Development Facilitation Team (DHO) – Review Comments

DRB Project No: PR-2019-003169 Date: 7/26/2023 Agenda Item: 1 Zone Atlas Page: L-10

Application For: PR2-2019-003169 – PRELIMINARY PLAT (DHO)

Case Description: Major Preliminary Plat for Sage Park Subdivision.

LEGAL DESCRIPTION
SAGE PARK SUBDIVISION
(BEING A REPLAT OF A PORTION OF TRACT 401)
TOWN OF ATRISCO GRANT, UNIT 3
CITY OF ALBUQUERQUE, NEW MEXICO

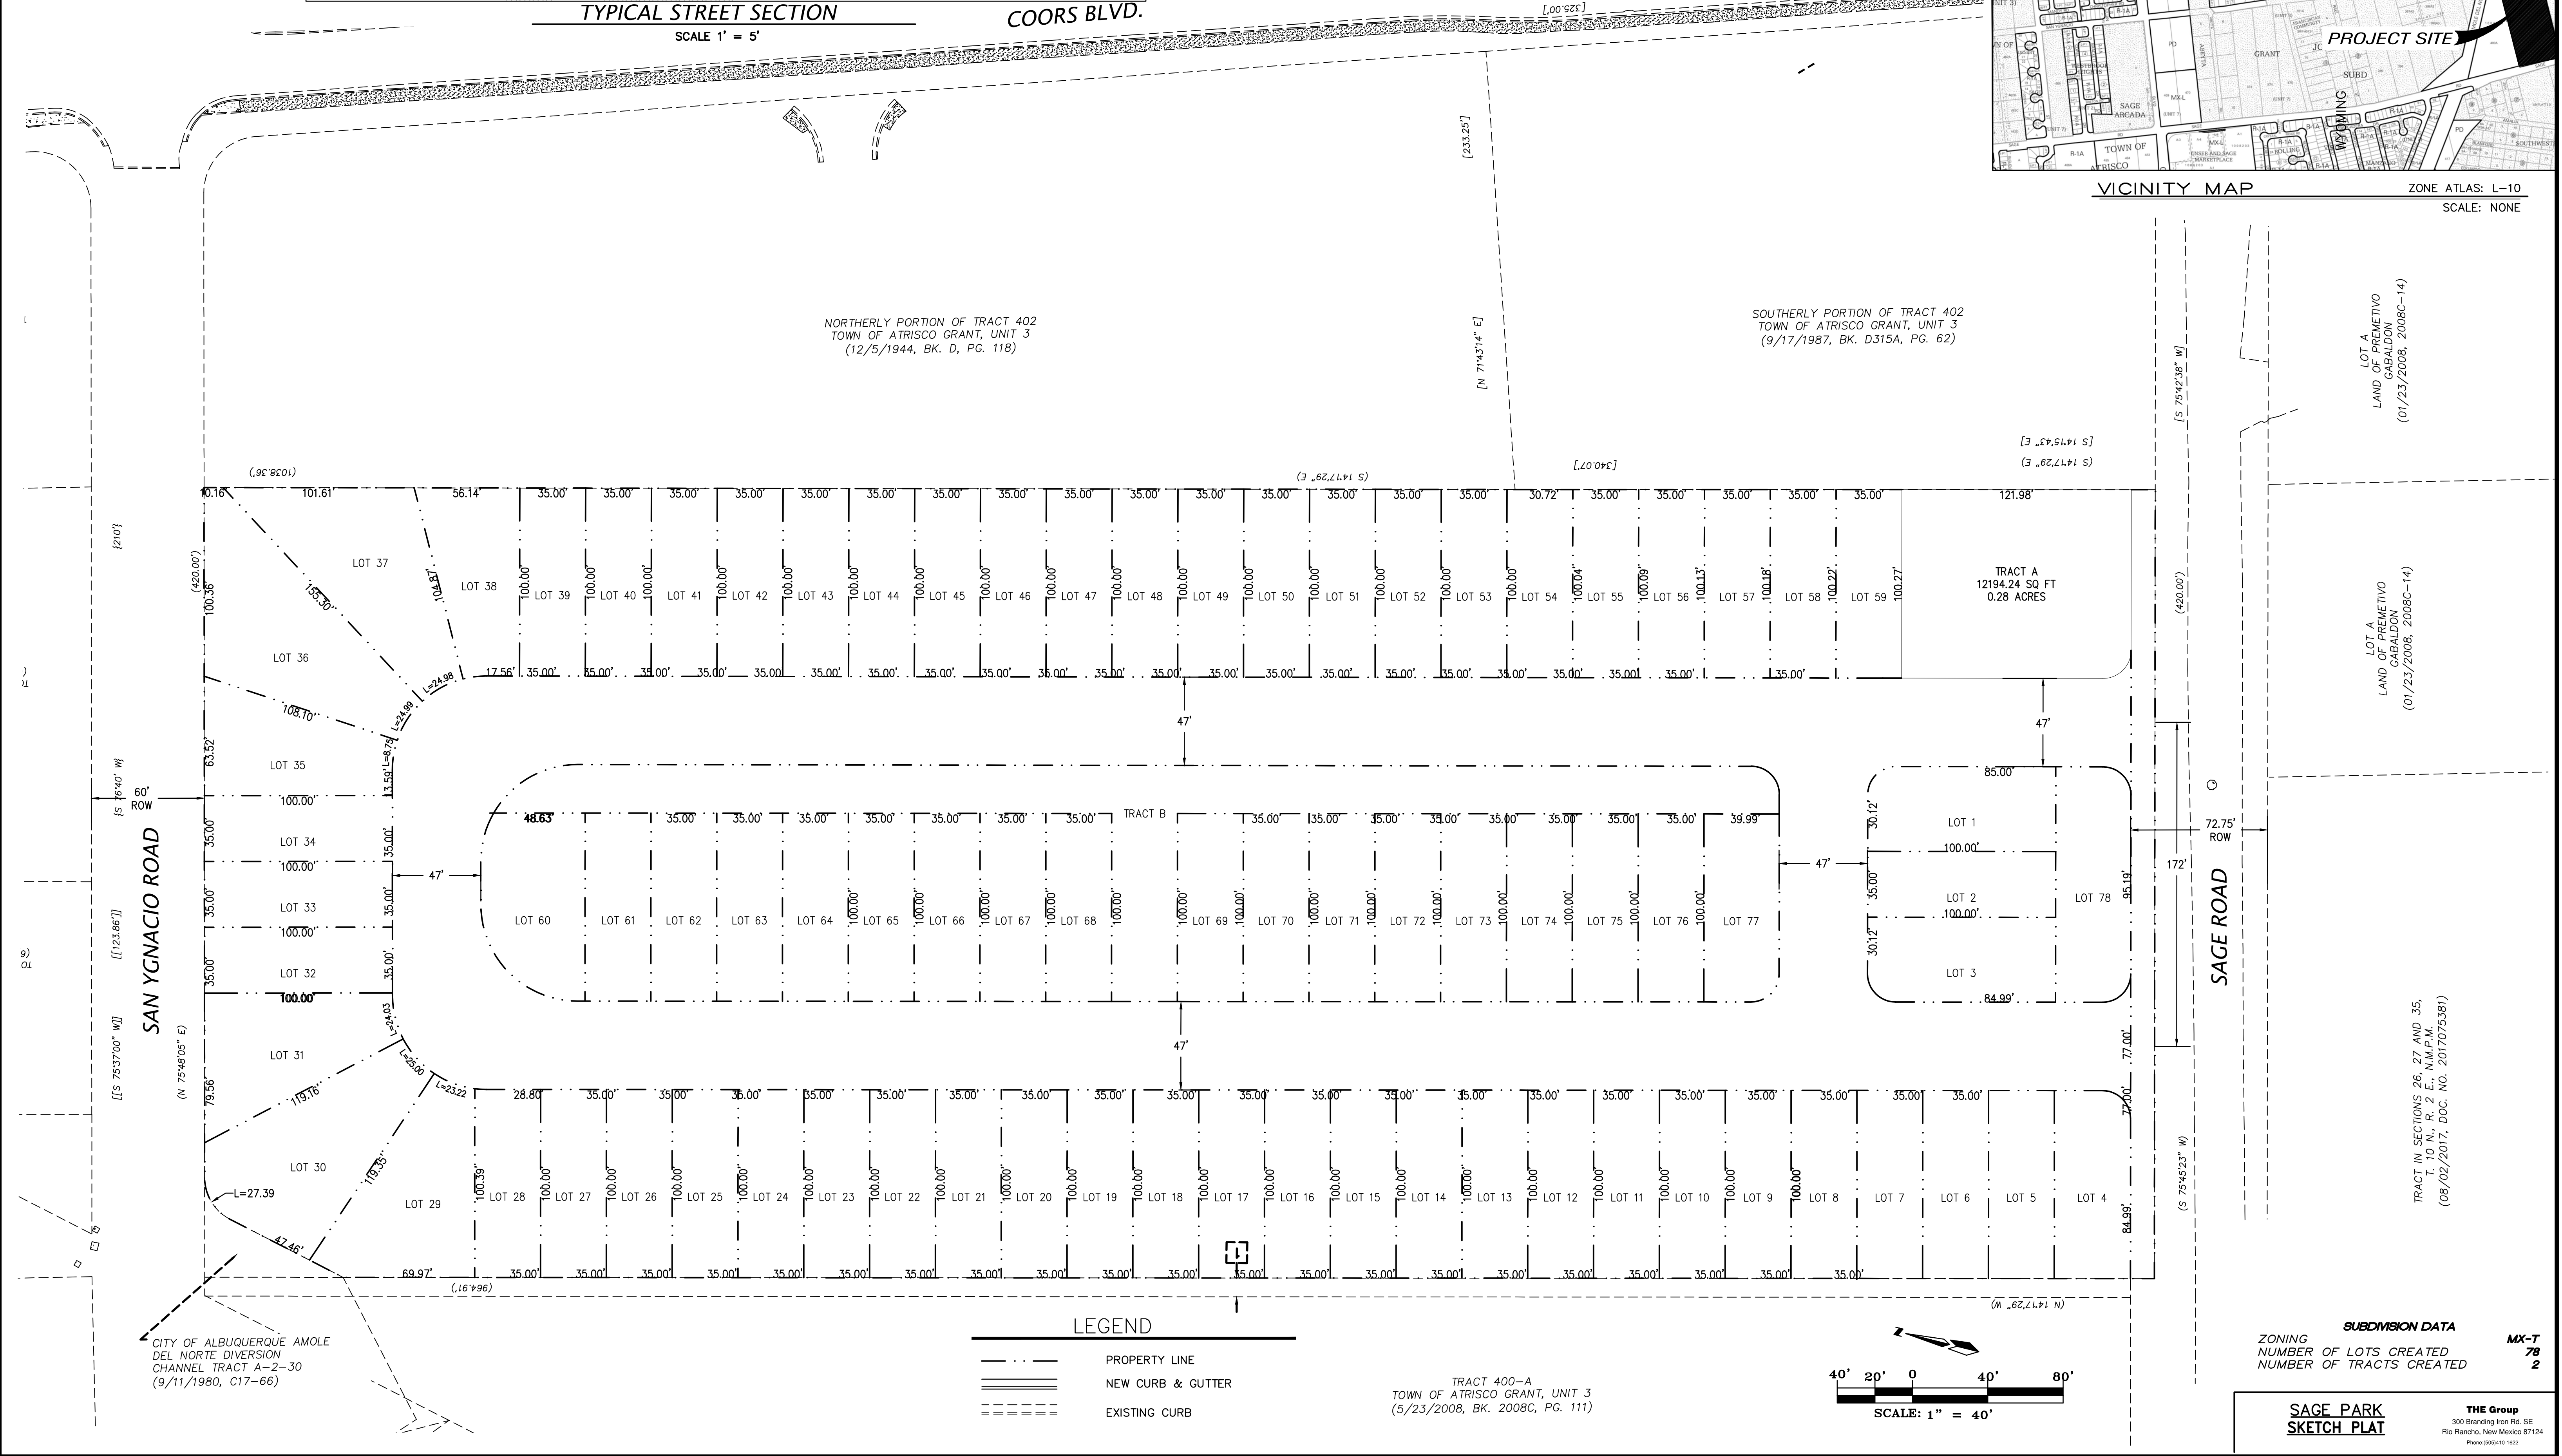
3. As per IDO 5-4(F)(2), “Residential lots shall avoid layouts where the rear lot line is adjacent to a collector or arterial street.” It appears that lots 1, 2, and 3 rear lot lines are adjacent to Sage Rd and may not be in compliance with this requirement. Please explain.
Adjacent (IDO Definition): Those properties that are abutting or separated only by a street, alley, trail, or utility easement, whether public or private.

- The application number for the Preliminary Plat must be added to the Infrastructure List.
- Lots 1 – 3 appear to depict their rear lot lines being adjacent to Sage Road, which is classified as a major collector. Per 5-4(F)(2)(b) of the IDO, residential lots shall avoid layouts where the rear lot line is adjacent to a collector or arterial street.
